**Consultation Response from KC,
Lead Local Flood Authority**

2025/93464 Spinksmire Mill, Huddersfield Road, Meltham, Holmfirth, HD9 4AN

Demolition of existing building and erection of industrial building

Date Responded: 15/04/2026

SITE AREA (AS DEFINED BY THE RED LINE) 0.54hec / 1.33ac

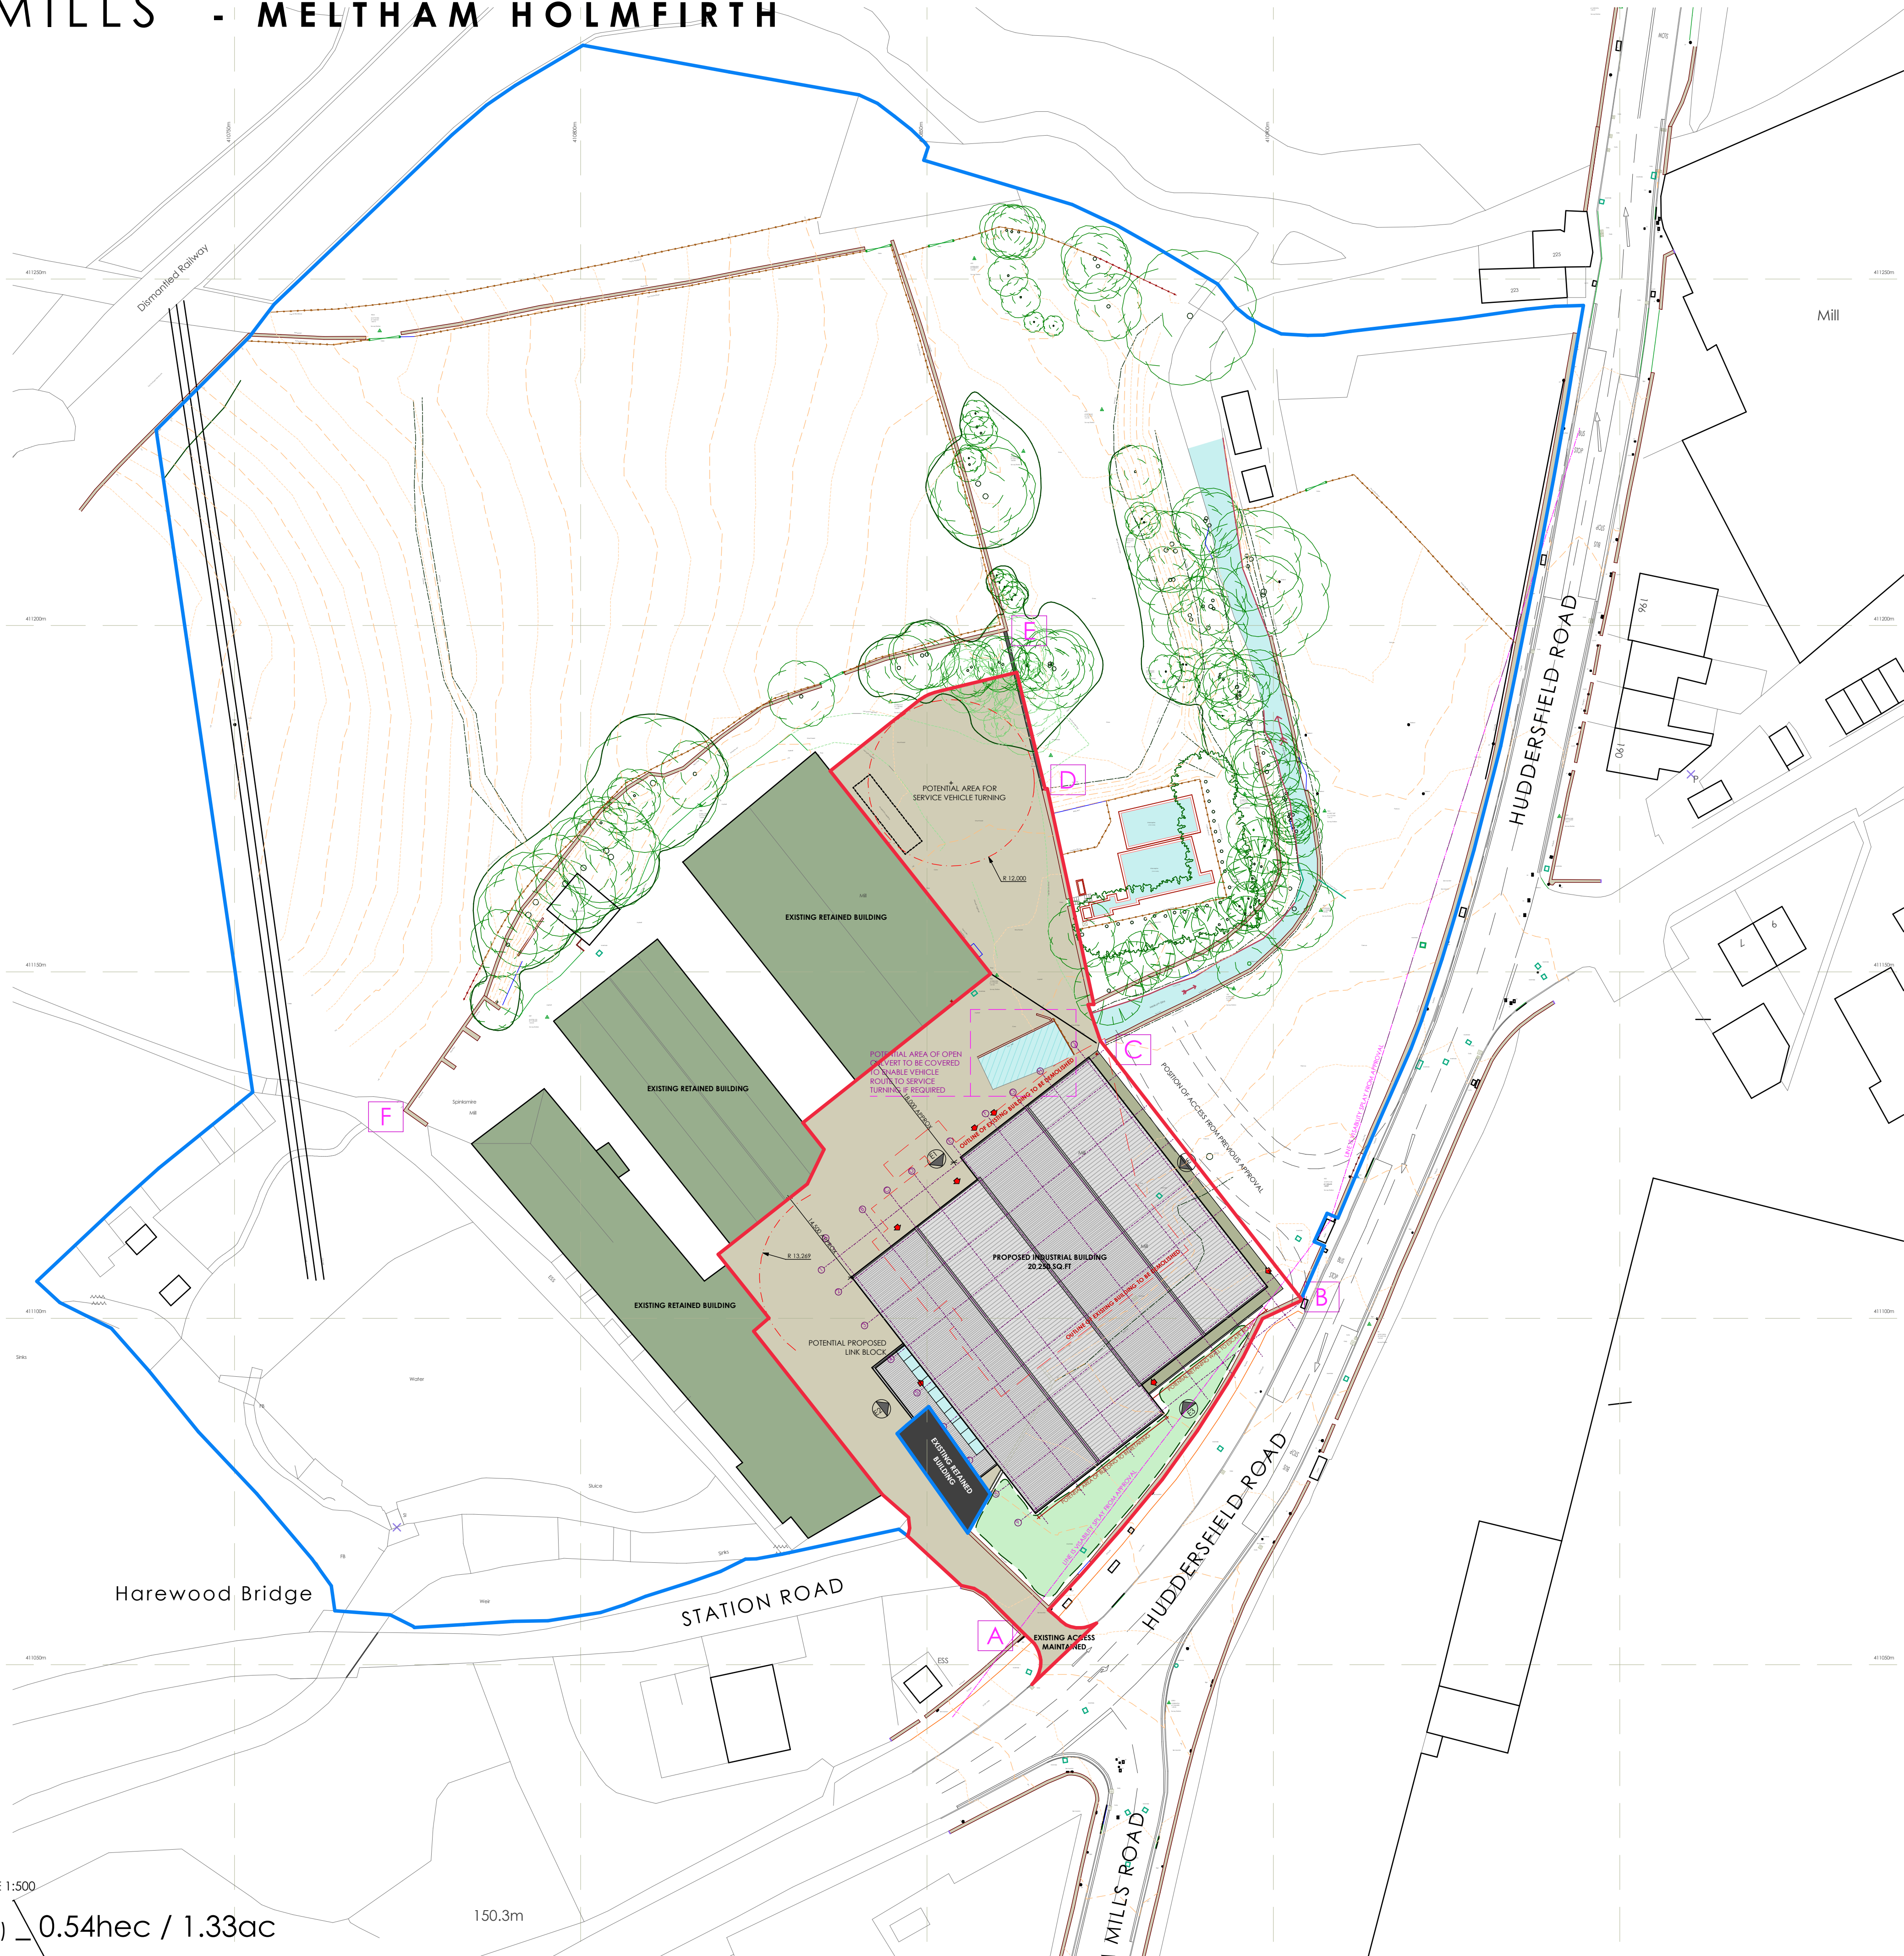
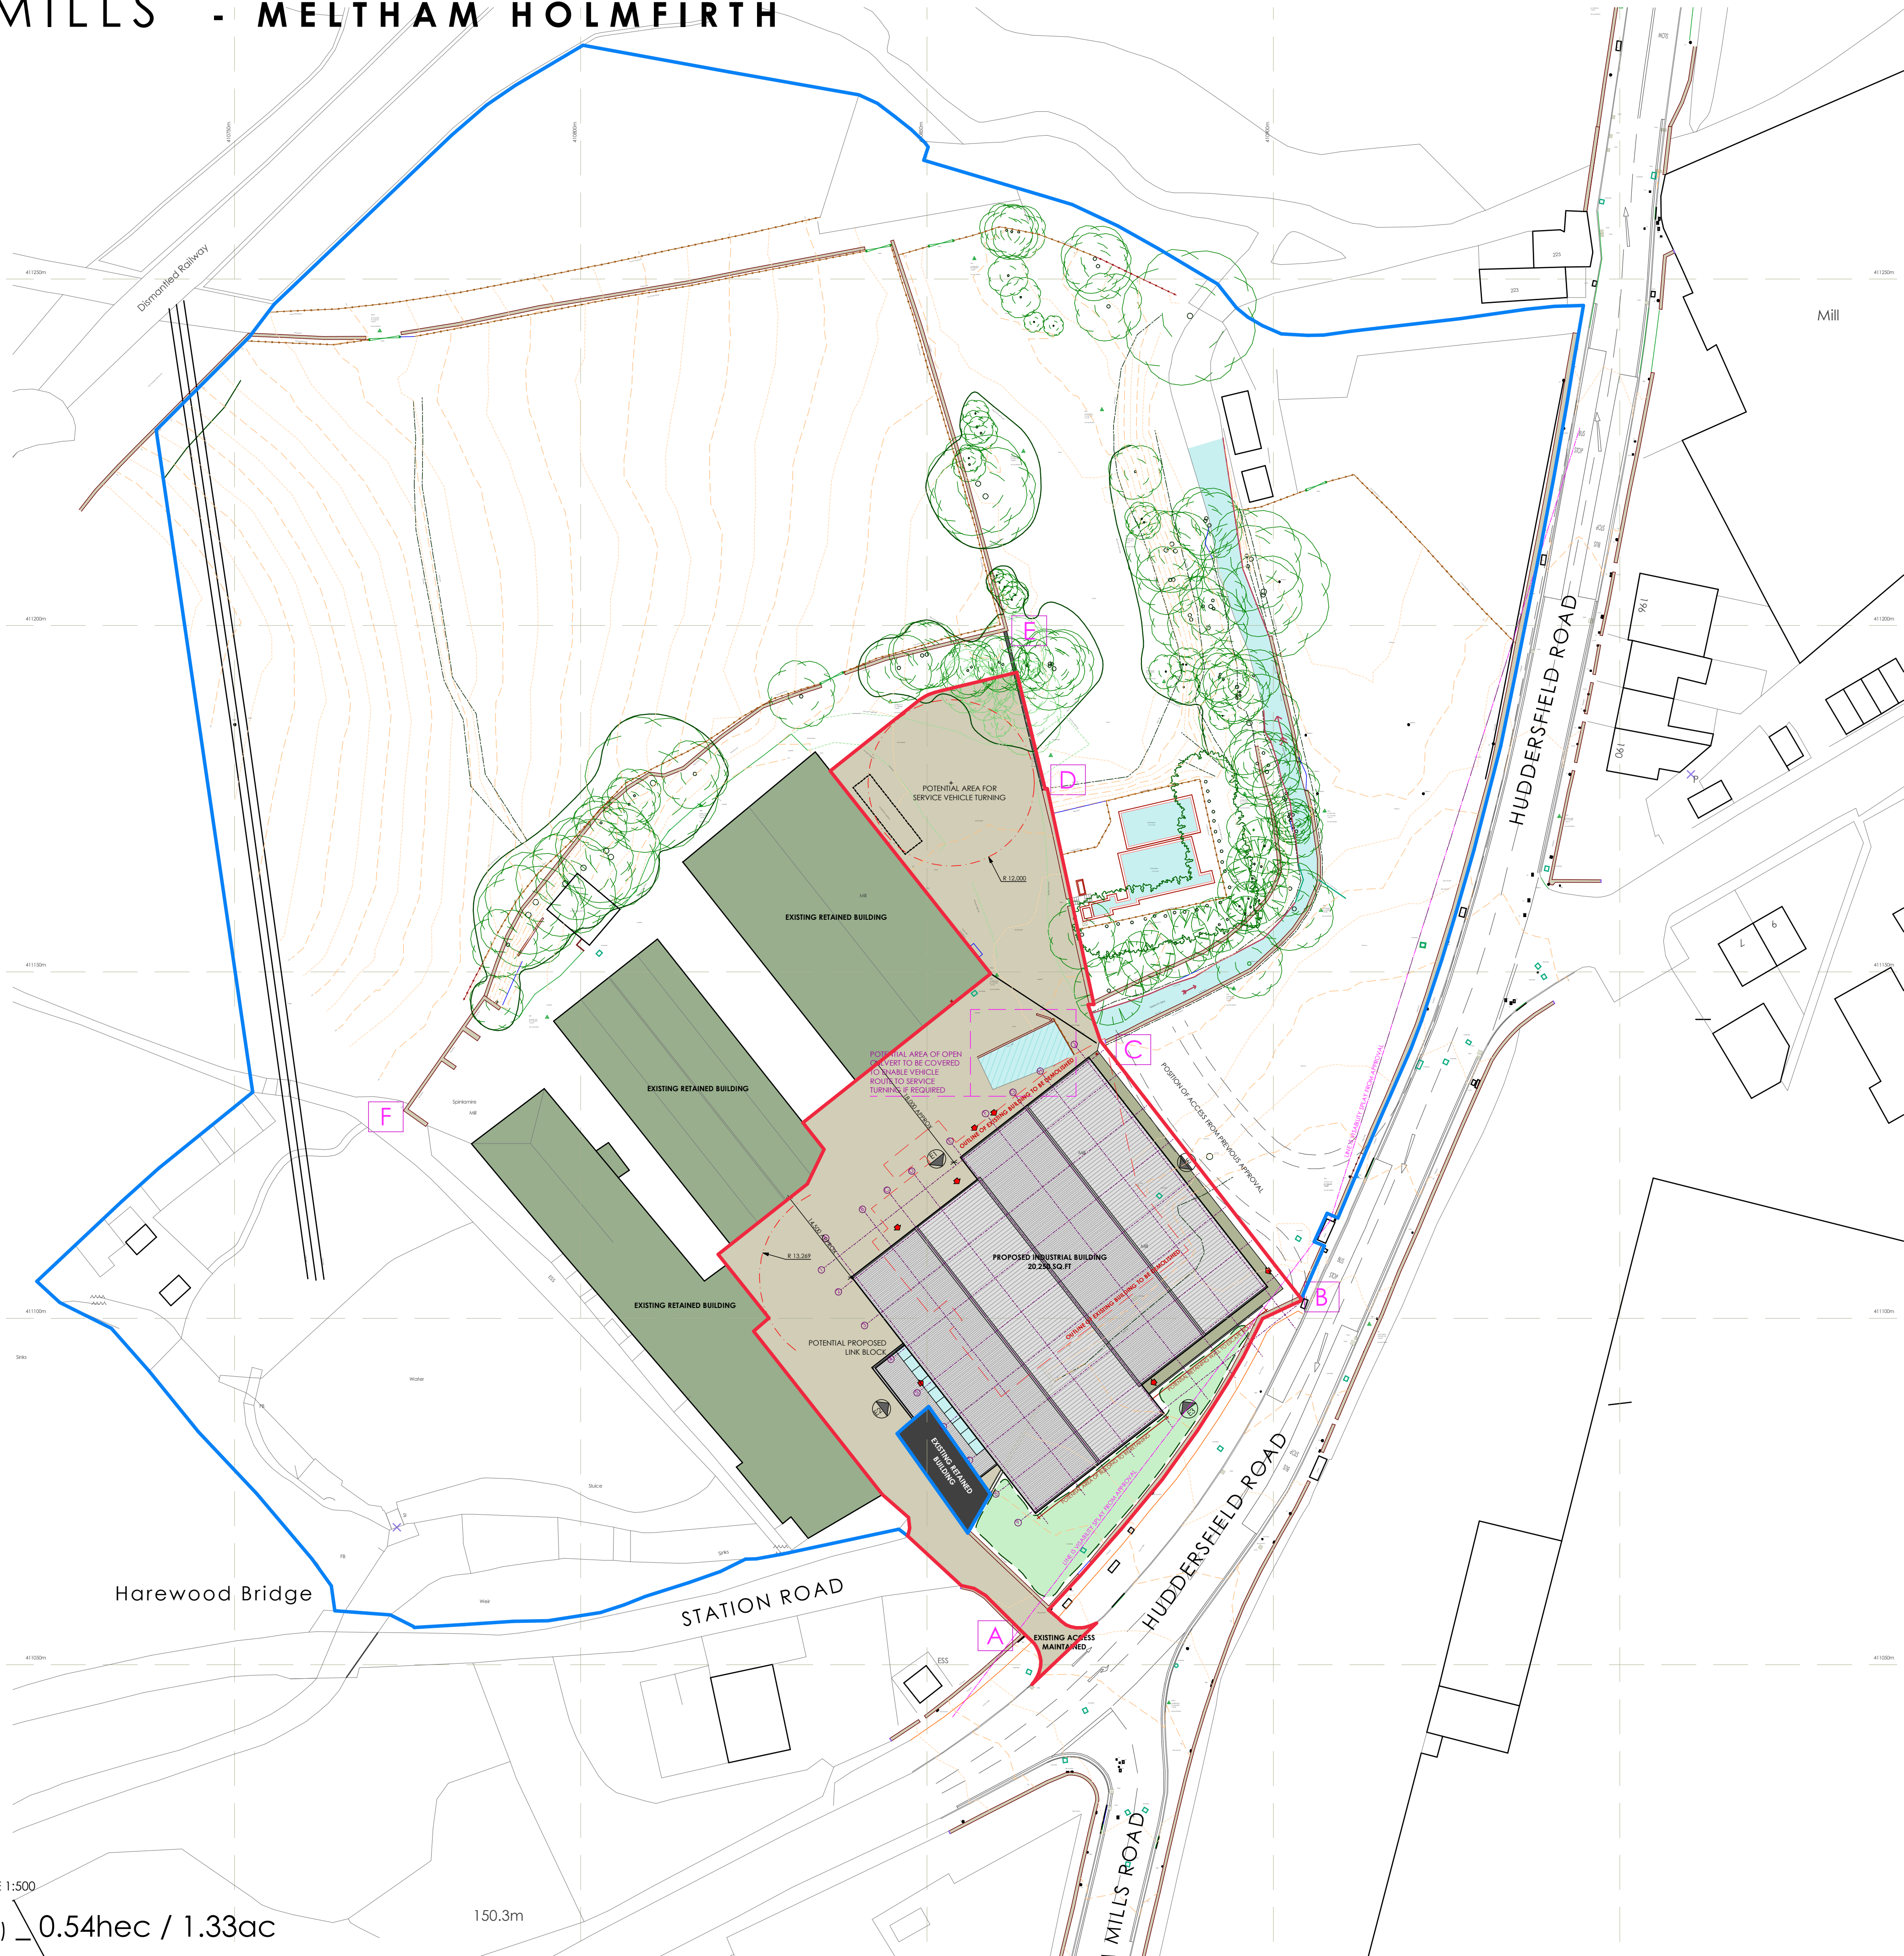
The LLFA confirms that the FRA produced by Andrew Moseley Associates is generally accepted, however it is noted that no drainage strategy has been submitted. In particular, the LLFA note that the proposed building is partly located on an unpaved area (i.e. rough grassland) to the south adjacent to Huddersfield Road which would increase the drained area by approx. 700m². This area would generate approx. 10l/s additional surface water run-off from the site (using the Modified Rational Method).

The FRA does not address the increase in surface water run-off or give the developer's proposals to avoid the associated increase in flood risk. The LLFA would also expect to be provided with details of how the new building, and any associated additional hardstanding, will dispose of surface water run-off.

Kirklees Flood Management and Drainage as Lead Local Flood Authority, OBJECTS to this planning application and requires further information as noted above.
